<b>Consultation Response from KC, Lead Local Flood Authority</b>
<b>2025/93229 Land off, Westgate, Cleckheaton, BD19 5DR</b>
<b>Discharge of details reserved by conditions 15 (drainage), 33 (waste), 37 (cycle parking), 41 (LEAP) on previous permission 2021/93567 for demolition of existing commercial buildings and erection of 180 dwellings with associated works</b>
<b>Date Responded: 22<sup>nd</sup> March 2026 Responding Officer: Paul Farndale Responding Ref:</b>

### **Condition 15 – Drainage**

Inlet Access, Maintenance and Low Flow Channel Details
Scale 1:50

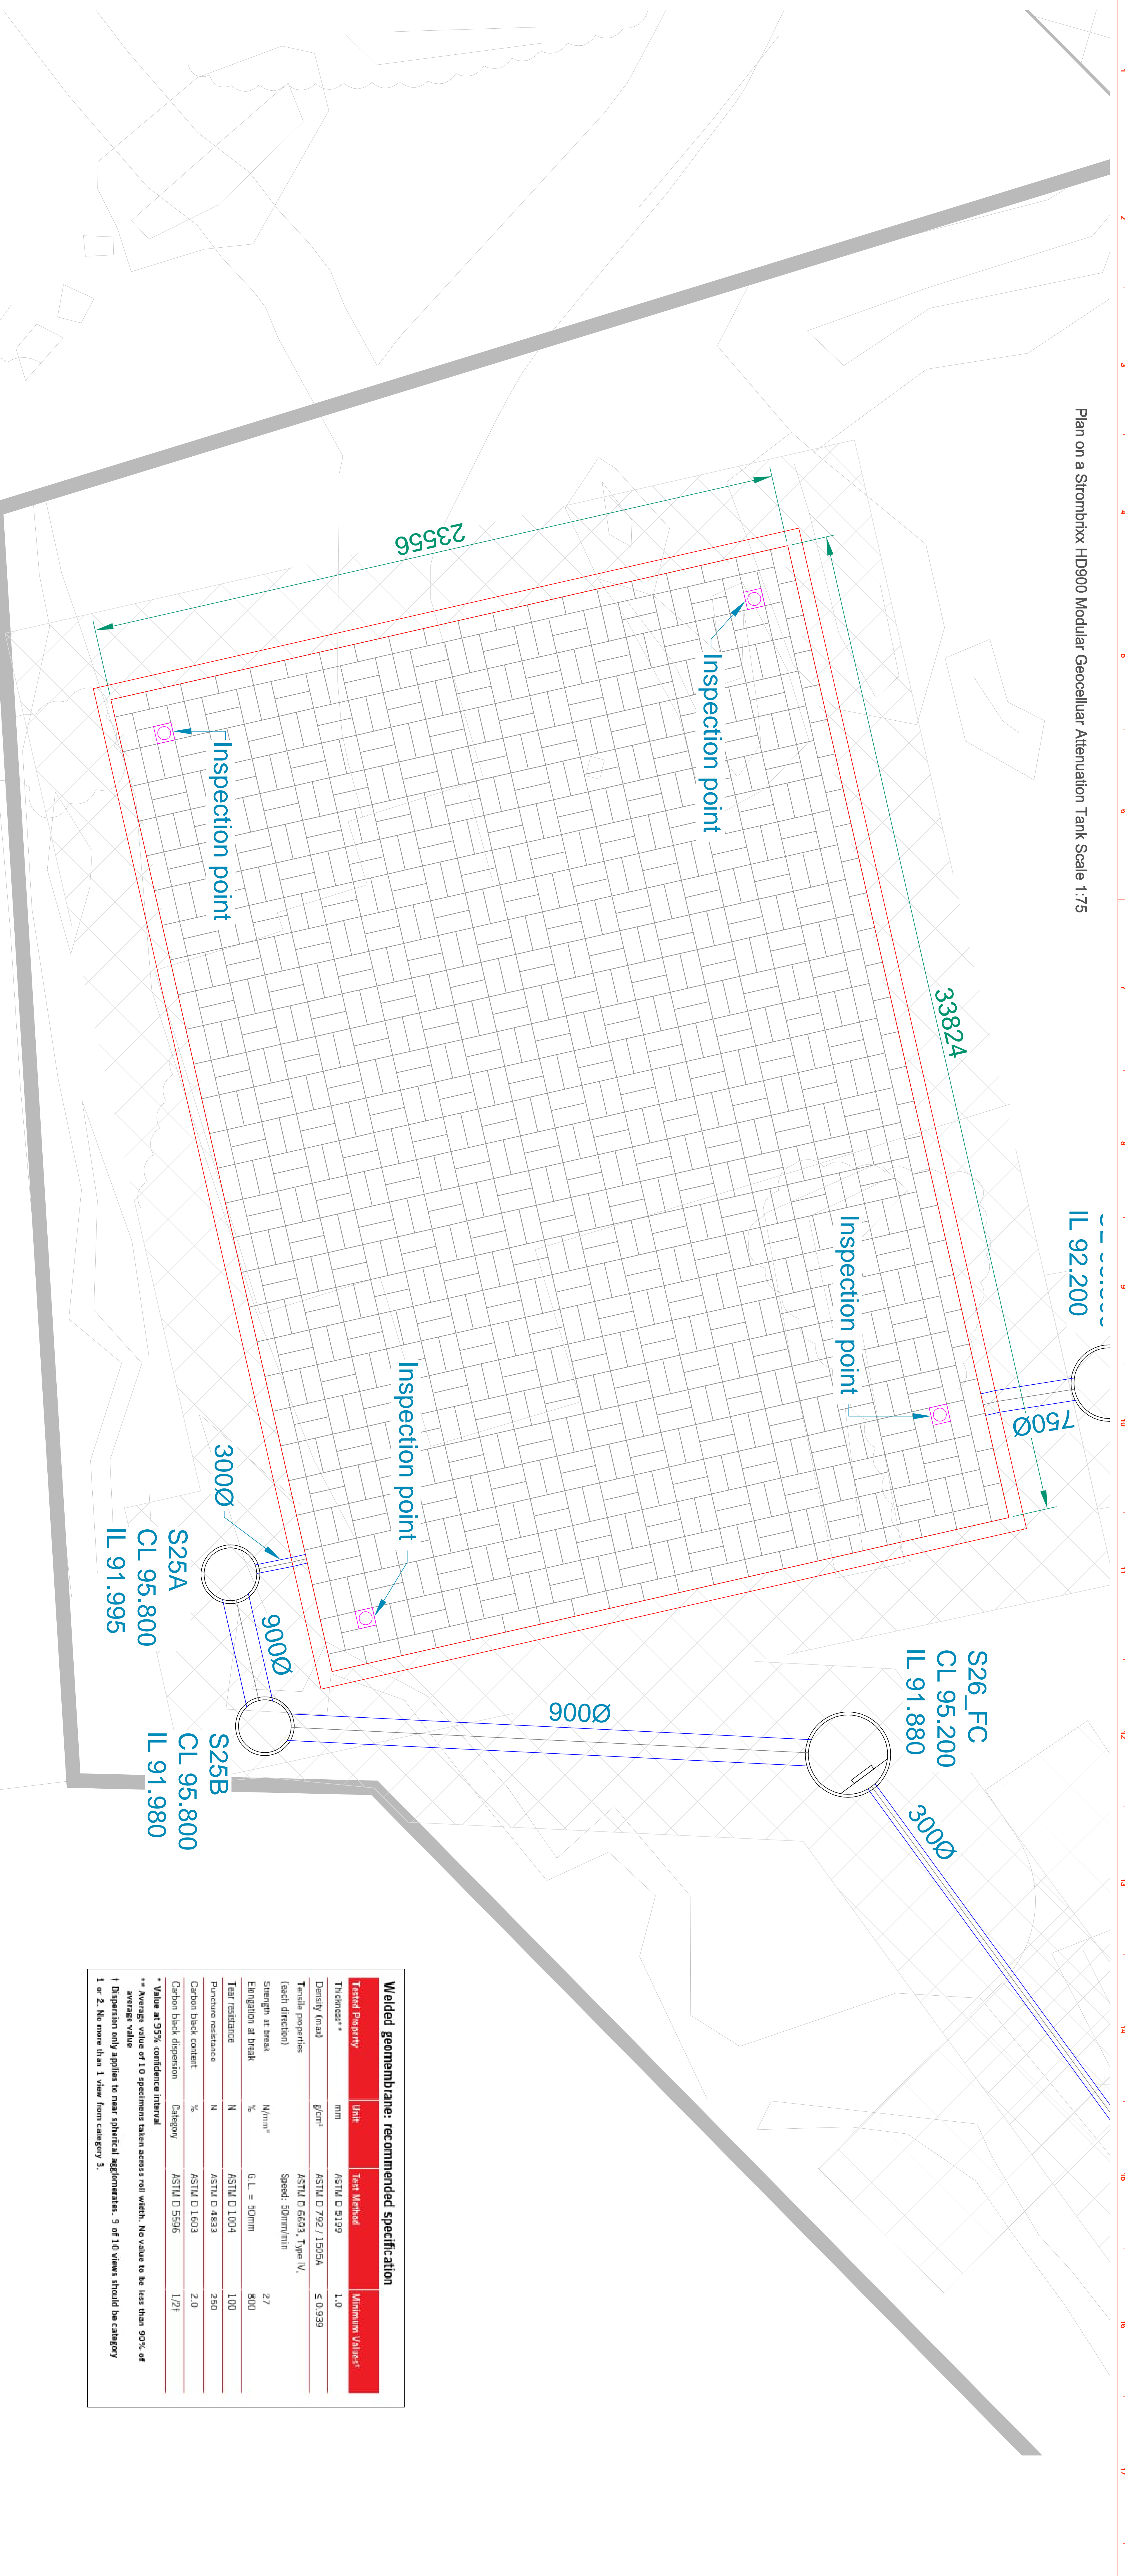
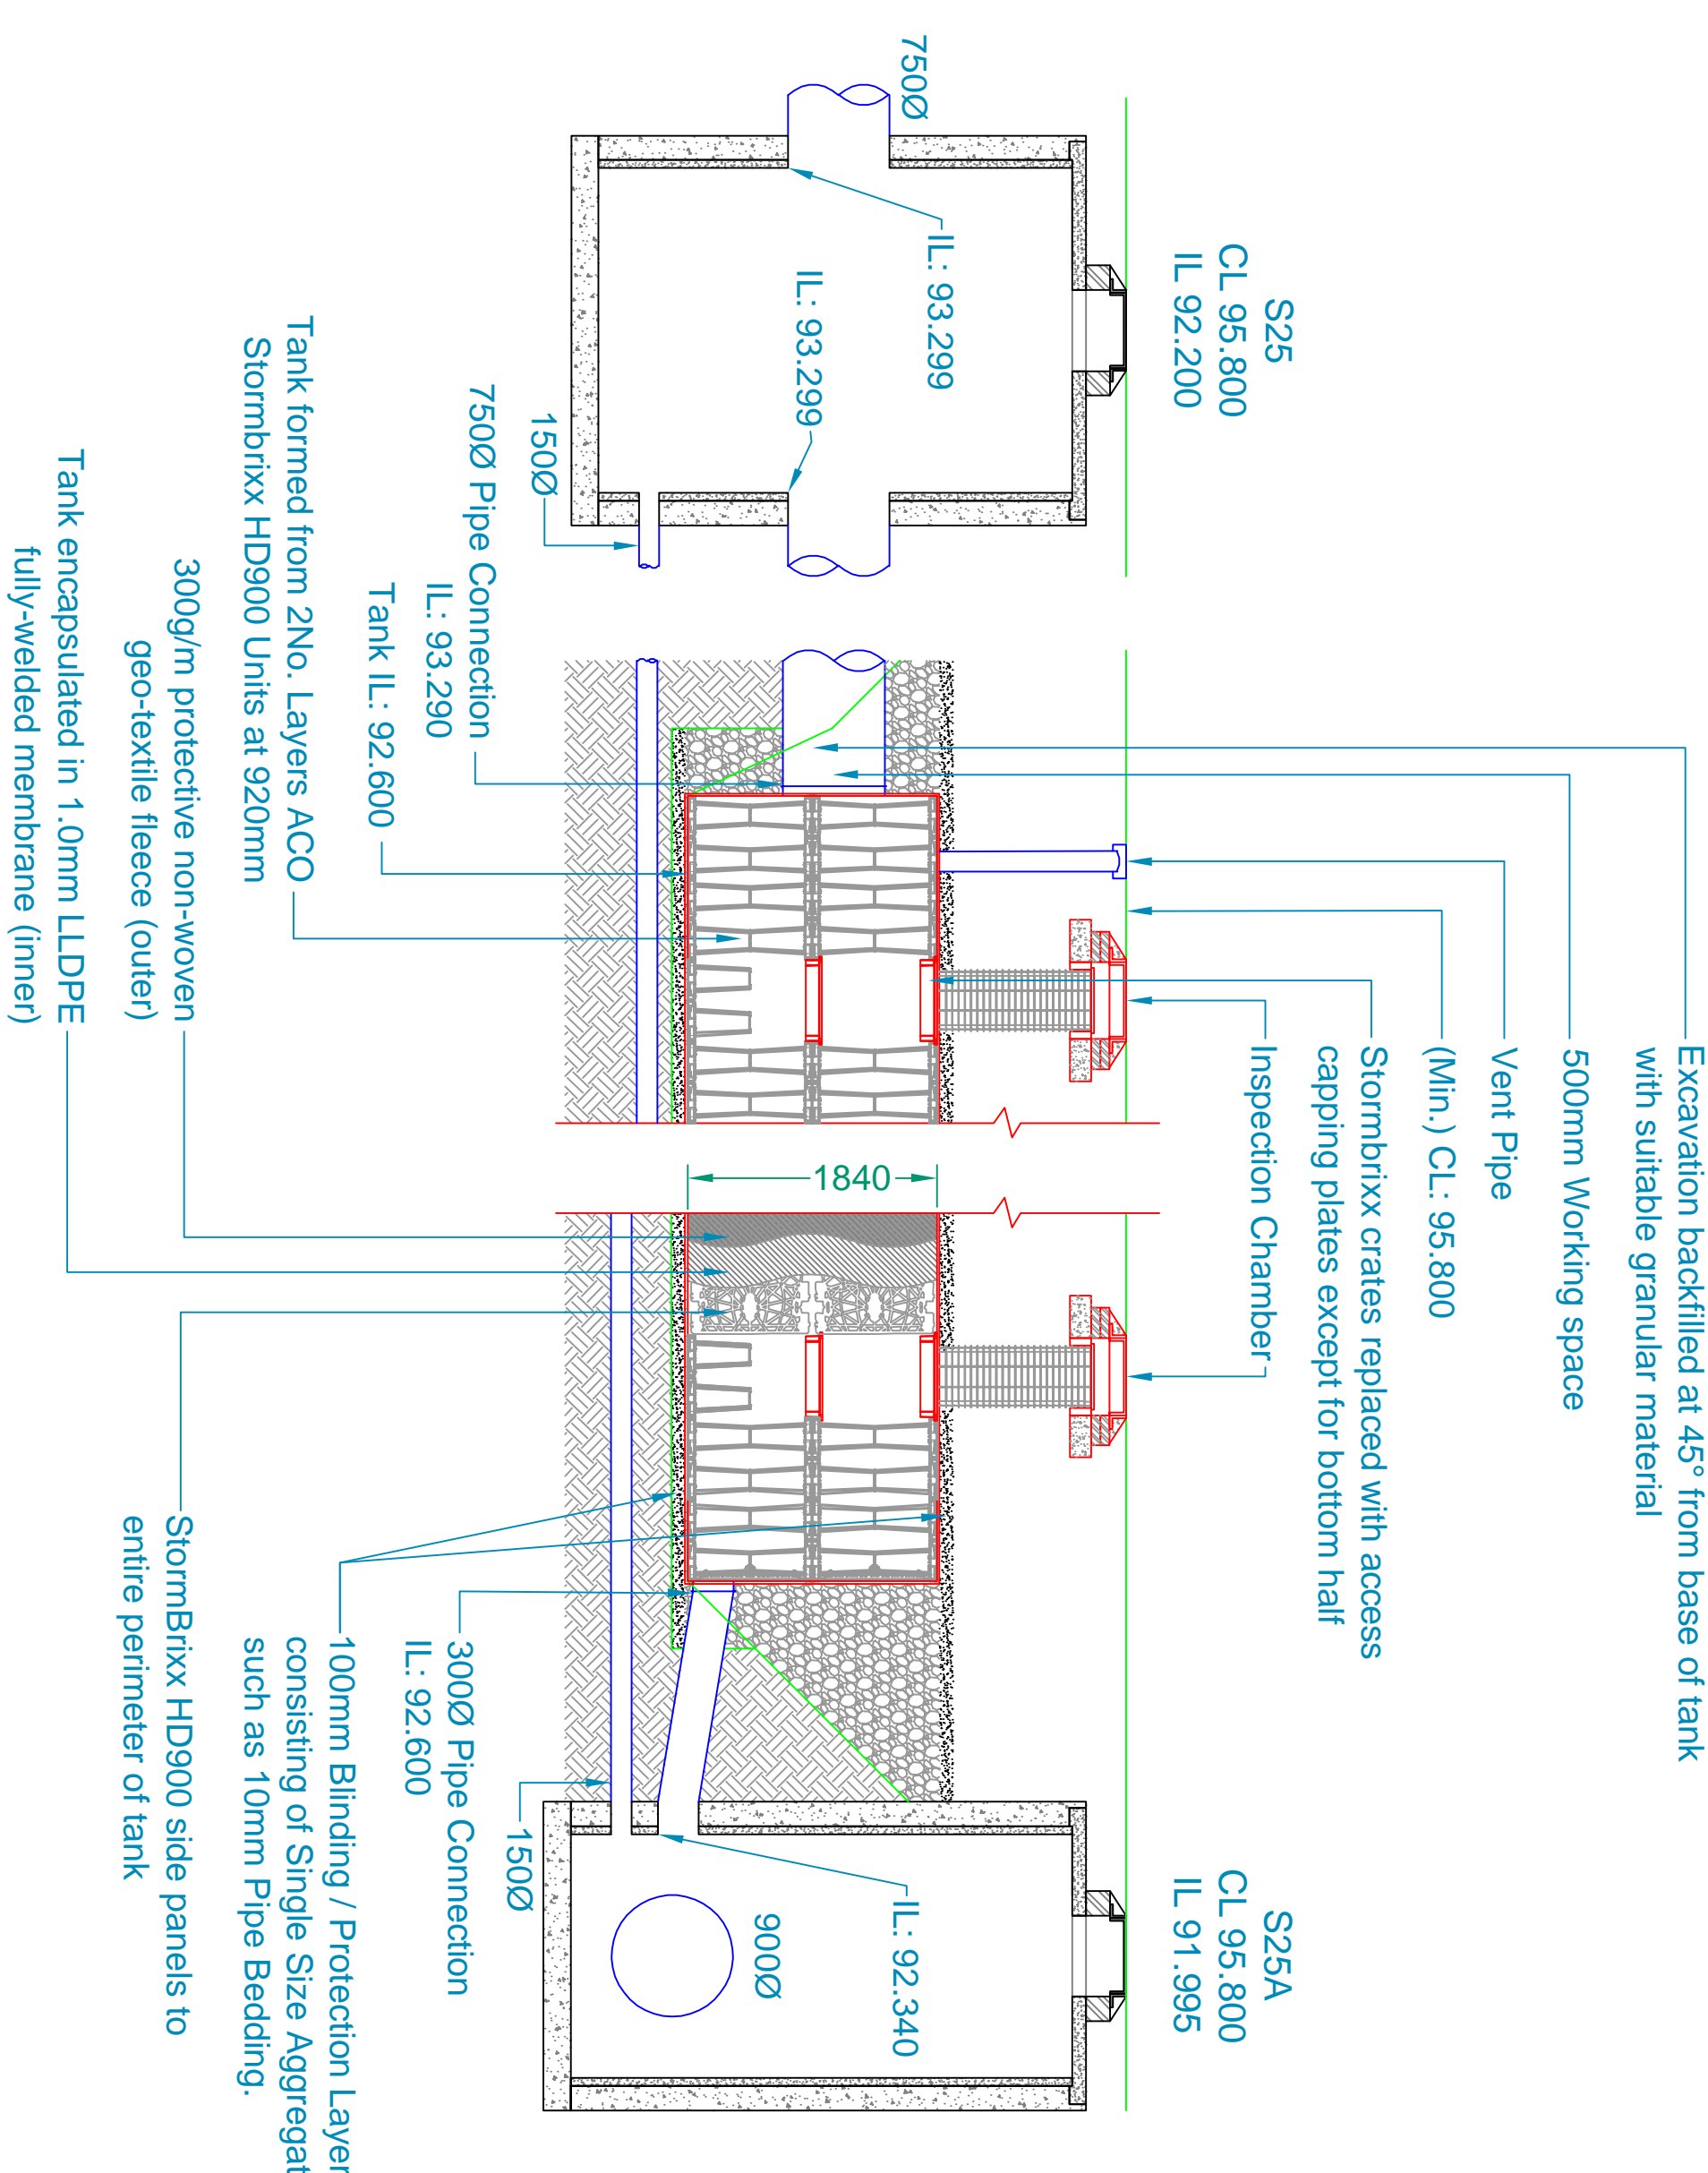
Full tank drawings have been supplied. There is no low flow channel shown although brochures suggest this can be incorporated. This should be considered for maintenance and access improvements or justified as to why it shouldn't be included. The movement of jetting hoses around all the struts from the shown access points for a tank this size will be problematic given the information provided an recommended methodology by the manufacturer (flexible hoses will be difficult to navigate).
